From: Simon Davis
Sent: 03 December 2019 13:21
To: Planning Scanning
Subject: FW: BR/233/19/PL - 77 Aldwick Road
Attachments: 77 Aldwick Road - Section Daylight VSC.jpg

From: James Hutchison [REDACTED]
Sent: 02 December 2019 17:32
To: Simon Davis [REDACTED]
Subject: RE: BR/233/19/PL - 77 Aldwick Road

REAR
PROPOSED ELEVATIONS
Scale 1:100

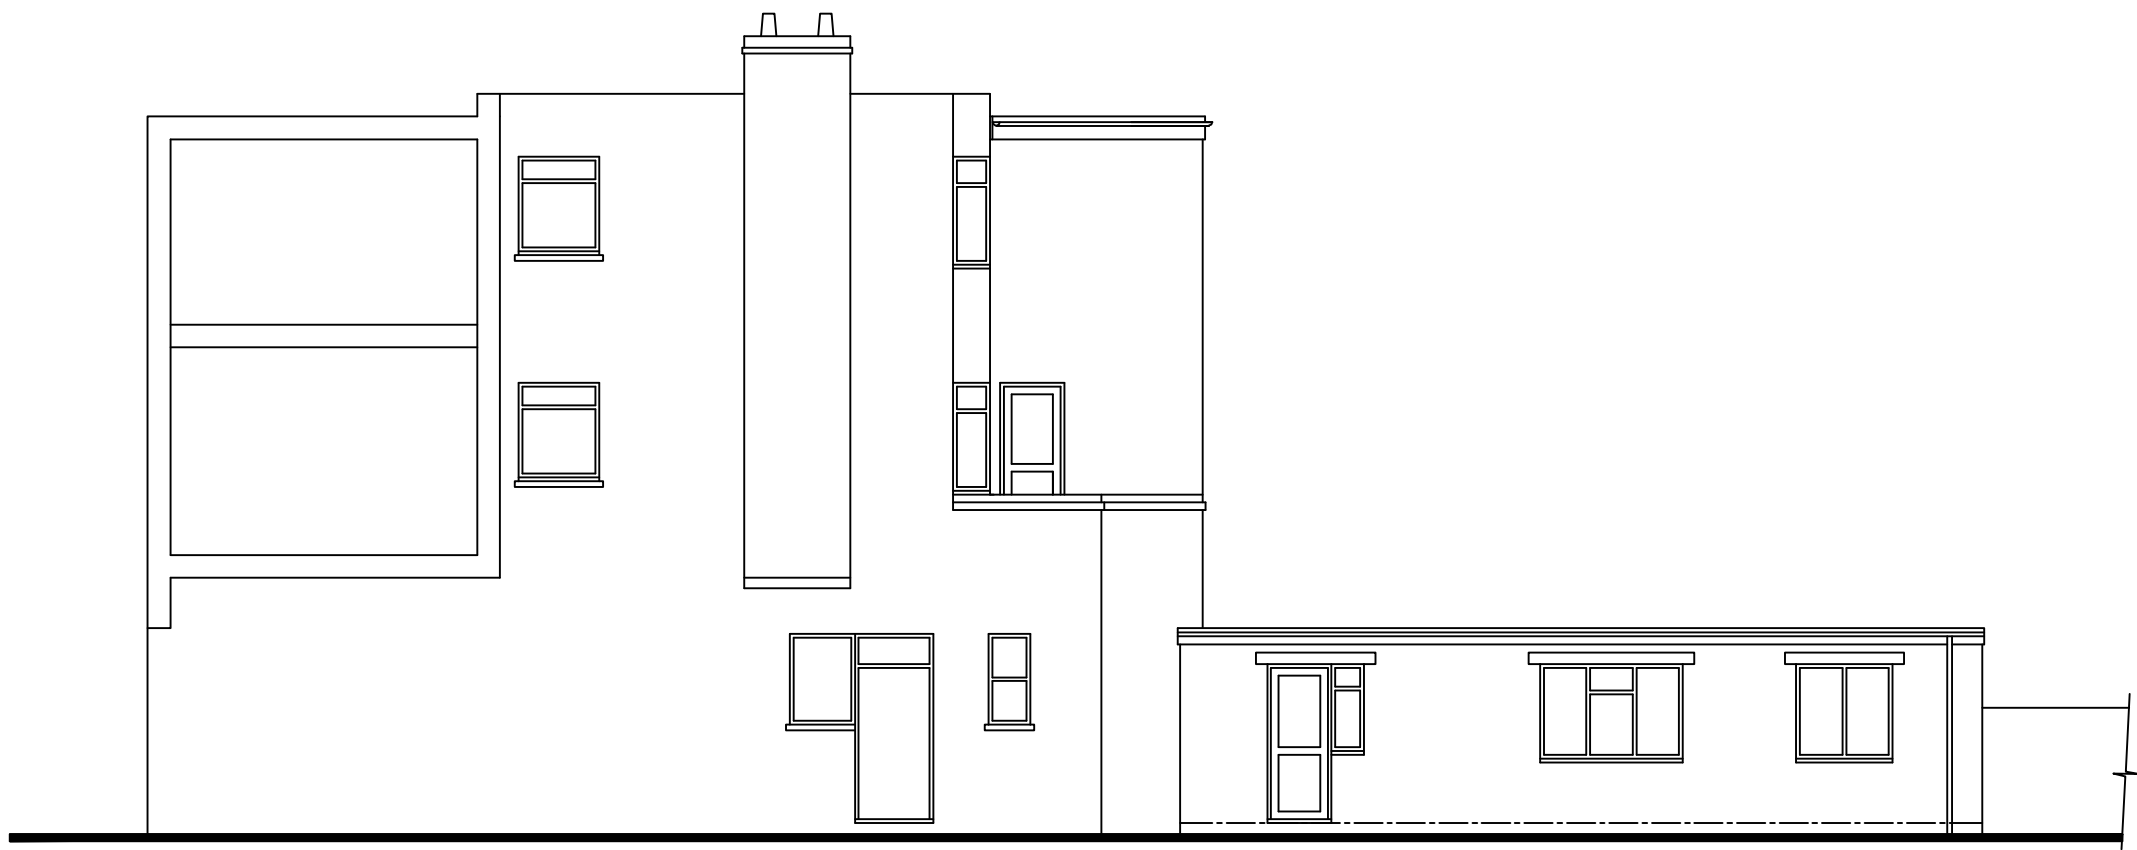
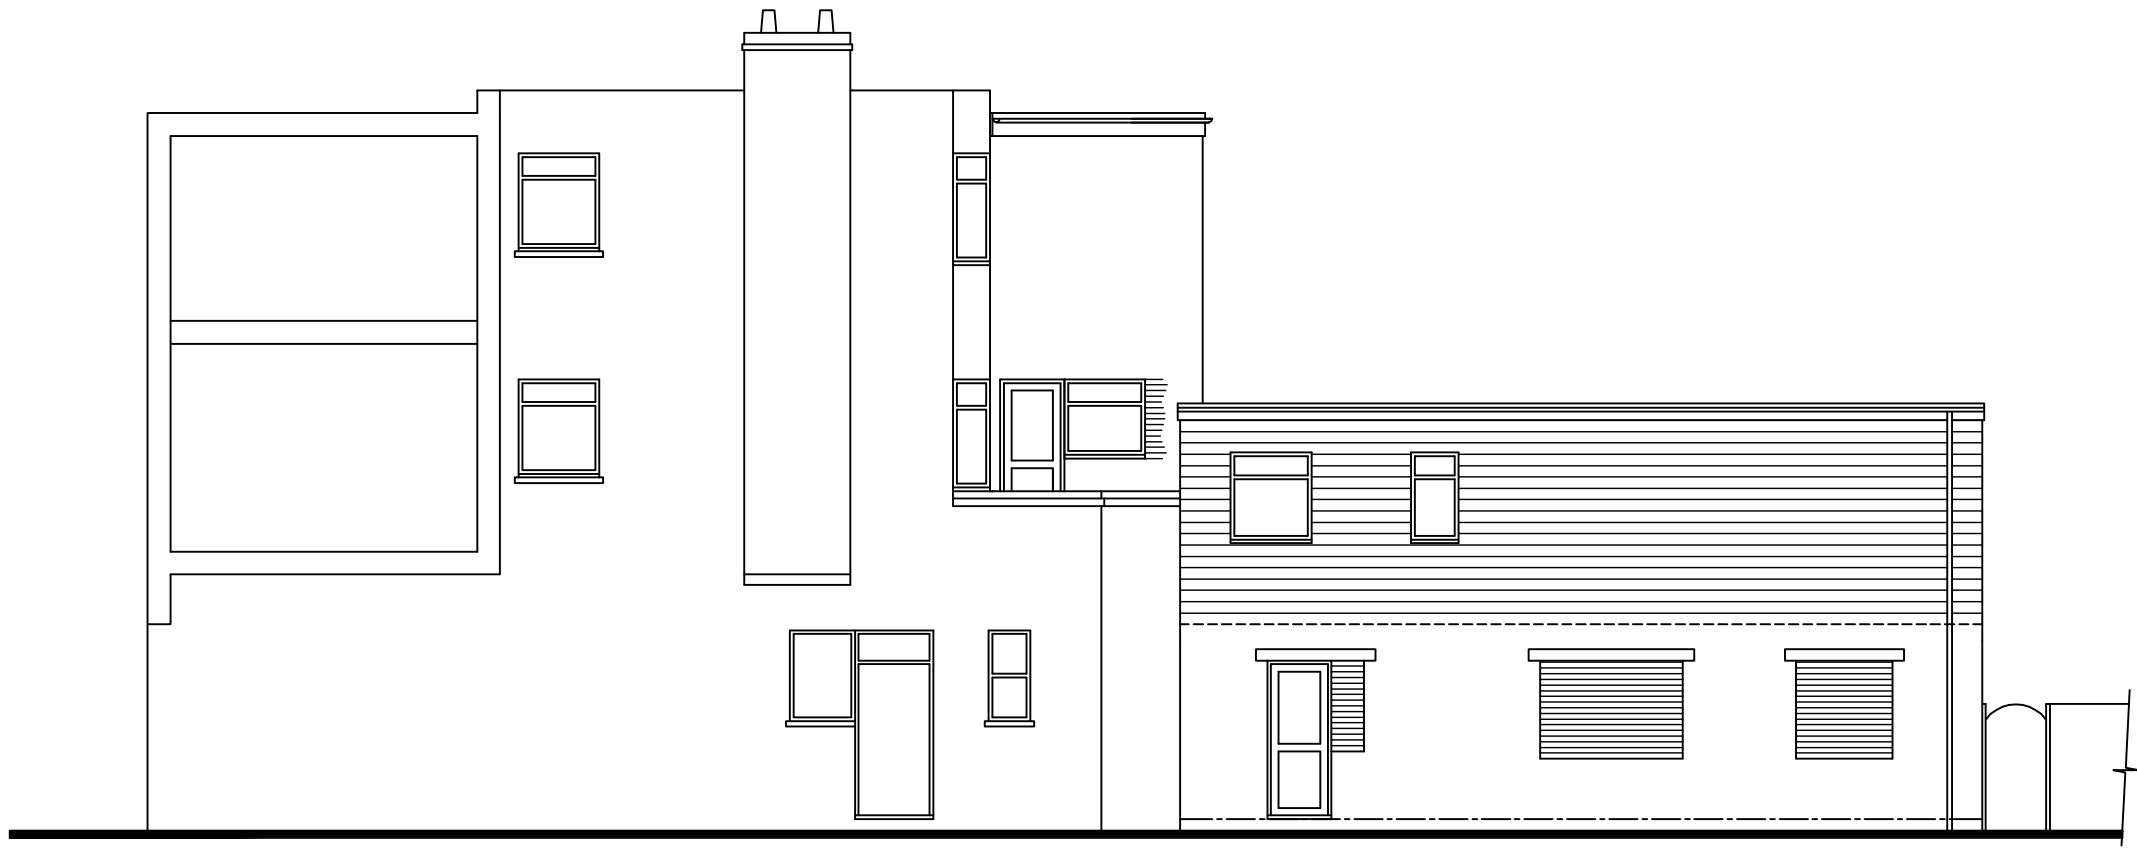
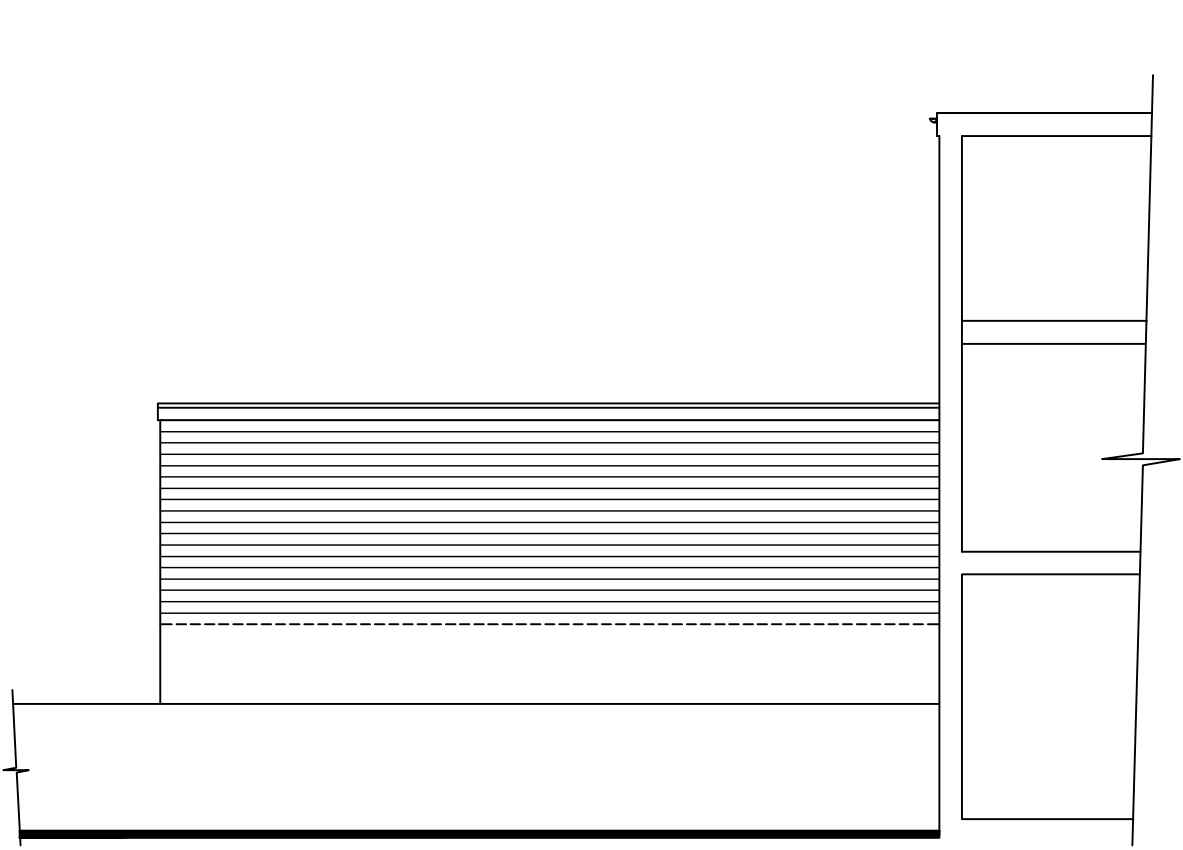
Thank you for confirming the windows that you feel would be adversely affected by the proposed development.

My reason for asking this question is because on our own assessment (using the appropriate VSC test within the BRE guidance) the proposed scheme complies on all windows and by a substantial margin.

"If any part of a new building or extension, measured in a vertical section perpendicular to a main window wall of an existing building, from the centre of the lowest window, subtends an angle of more than 25o to the horizontal, then the diffused daylighting of the existing building may be adversely affected.."

I have attached to this e-mail a quick overlay of the VSC test as applied to the western elevation (i.e. a vertical section showing the 'affected' window) of the proposed development. The VSC test has been carried out using the centre point of the lowest window as per the BRE guidance (and also using the 2m from FFL as is also commonly used). Both VSC lines comfortably sit well above the proposed extension meaning that the diffused daylight is, quite simply, not going to be adversely affected. On this basis, an assessment using universally applied BRE methodology supports our case that there would not be an adverse impact.

I have applied the VSC test to the nearest habitable room window (i.e. the first floor rear facing opening serving a living area of no.77) as this should show the worst-case scenario in terms of any potential loss of daylight or outlook. The kitchen of no.77 has no seating area or means to accommodate a seating area and is not a habitable room. However, evidently, even were you to apply the VSC to the kitchen window, with a higher centre point and by virtue of the fact that the extension is not perpendicular, the test would be easily passed. The further away the openings at nos. 75 and 79 means the less they are to be impacted.

The relevant windows would be (1) the existing first floor flat's living/dining room window and the terrace/balcony which it shares with its kitchen; (2) the rear/rear side windows and terrace/balcony of the first floor flat on 79 next door and (3) the rear windows of the first floor on 77 next door.
